PLANNING APPLICATION 21/02339/REM

I am writing with the comments of Middleton Stoney Parish Council on the above proposal:

TITLE
**S278 OFFSITE HIGHWAY WORKS
SPINE ROAD ACCESS
GENERAL ARRANGEMENT
SHEET 1**

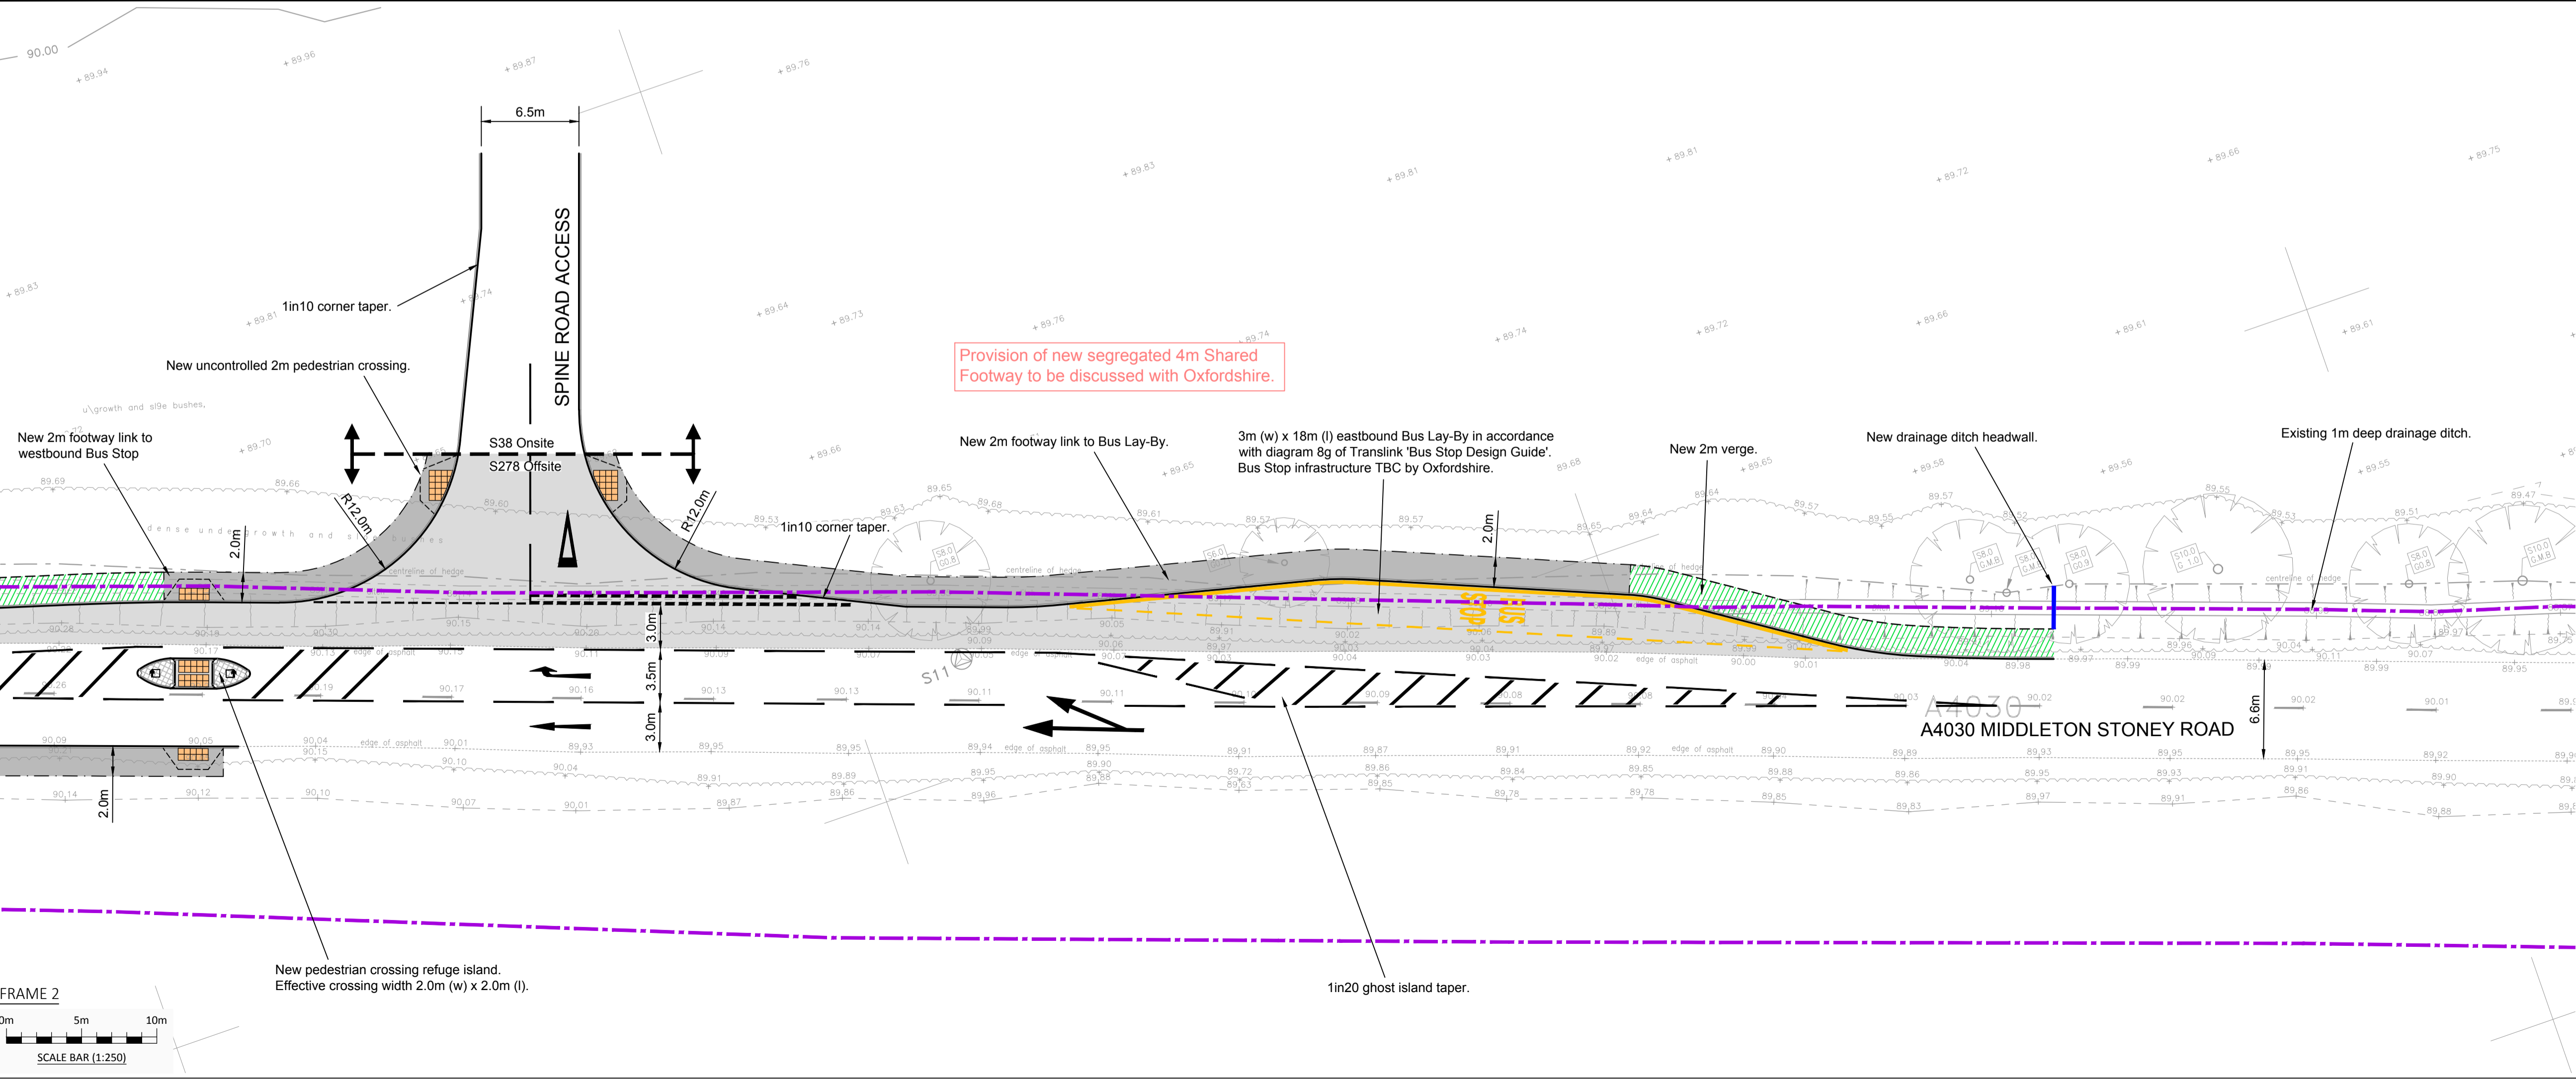
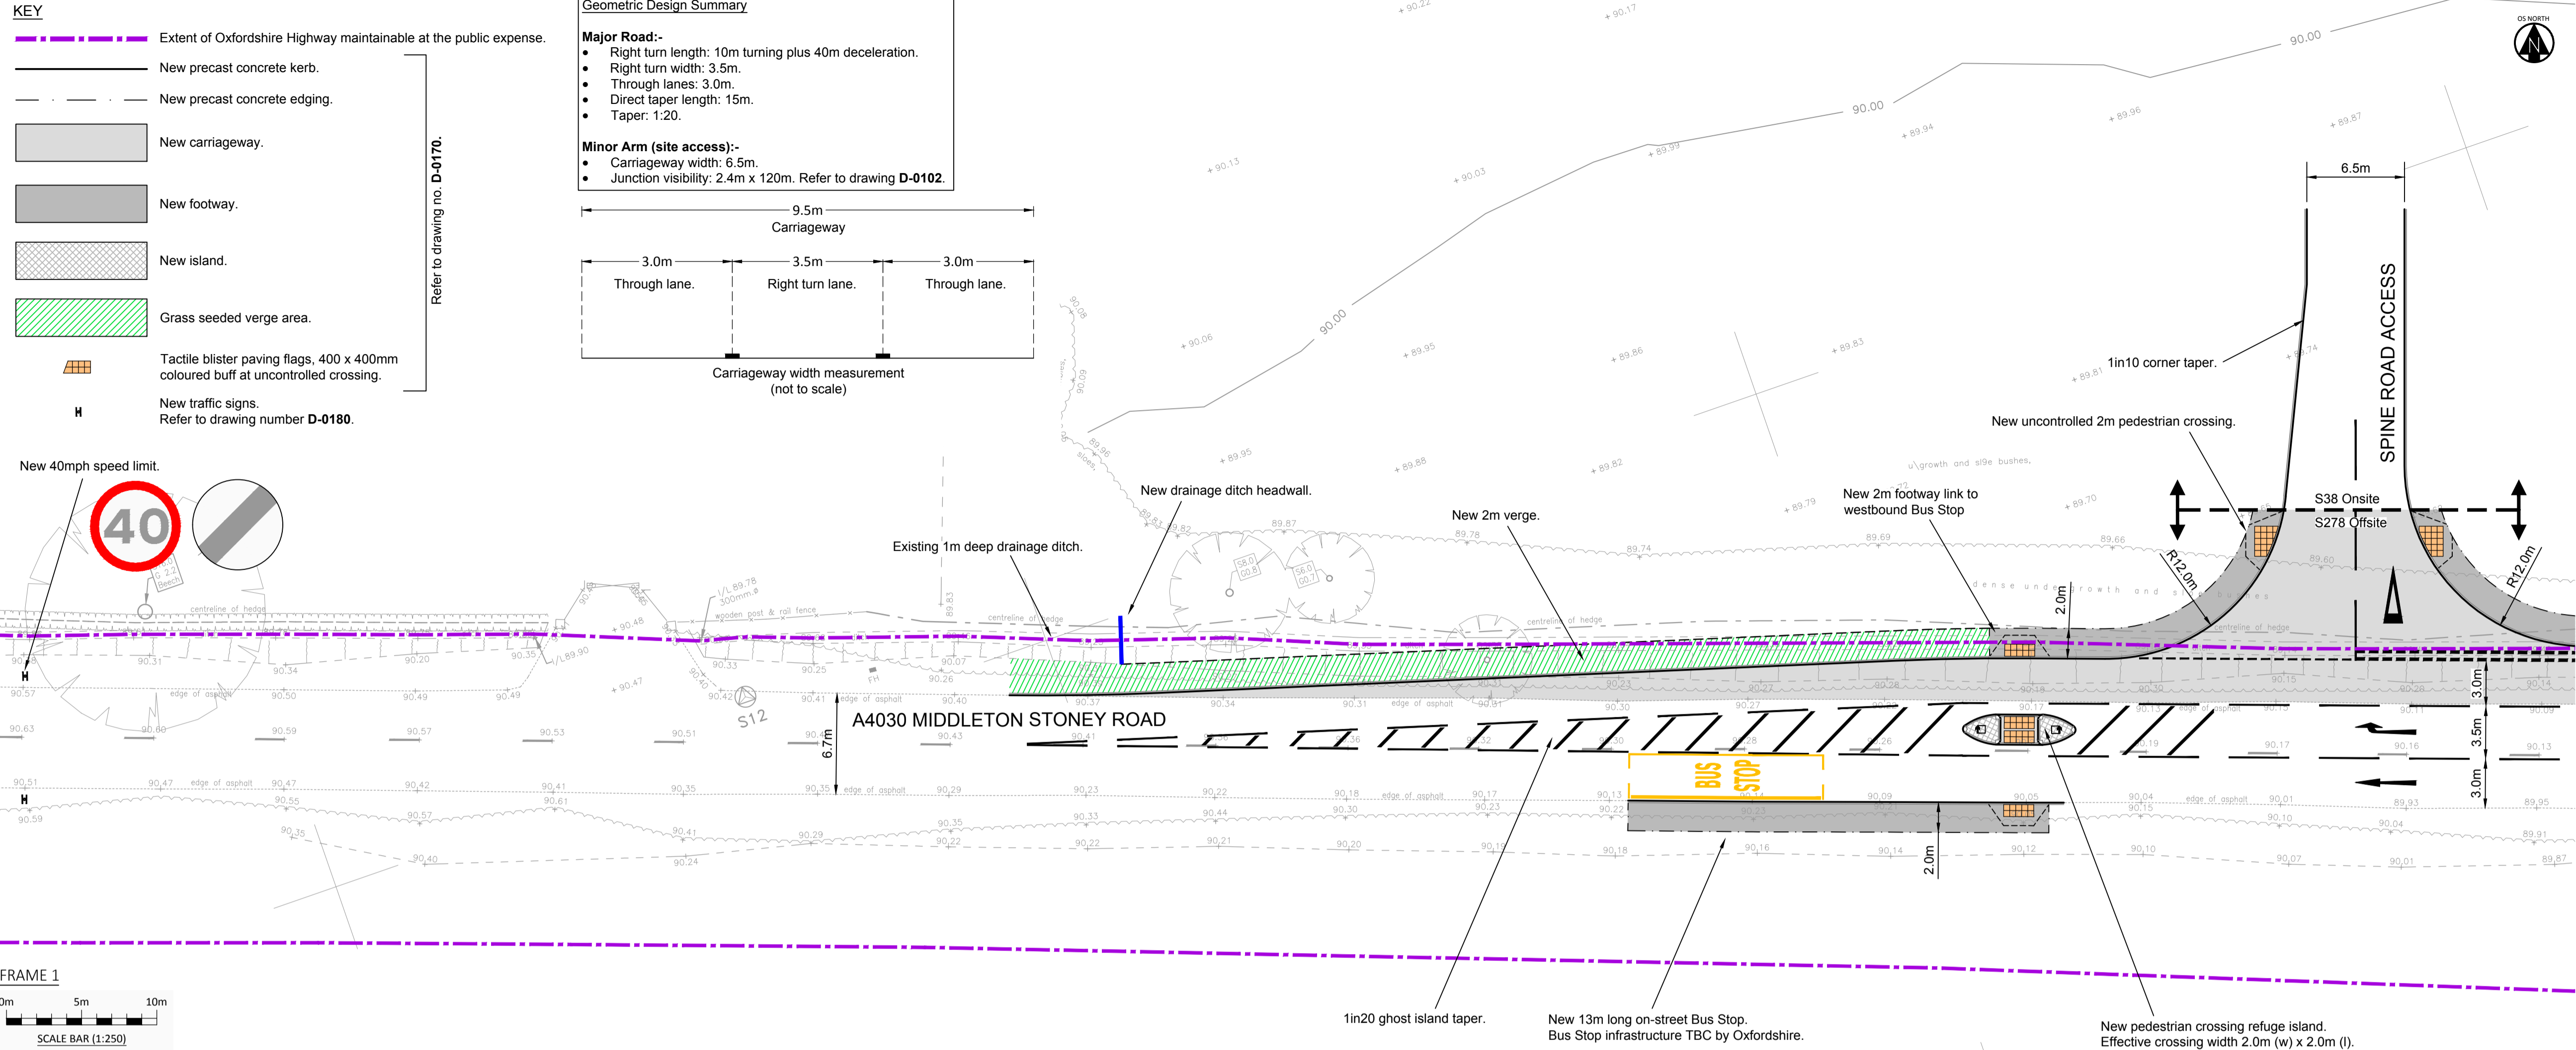
3. More specifically we would like to see the plans contain the cycle/pedestrian path along the Bicester Road past the next development entrance. At the moment the "off site" plans which cover the highway development do not include it, and it is only listed as proposed within the Transport Plan.
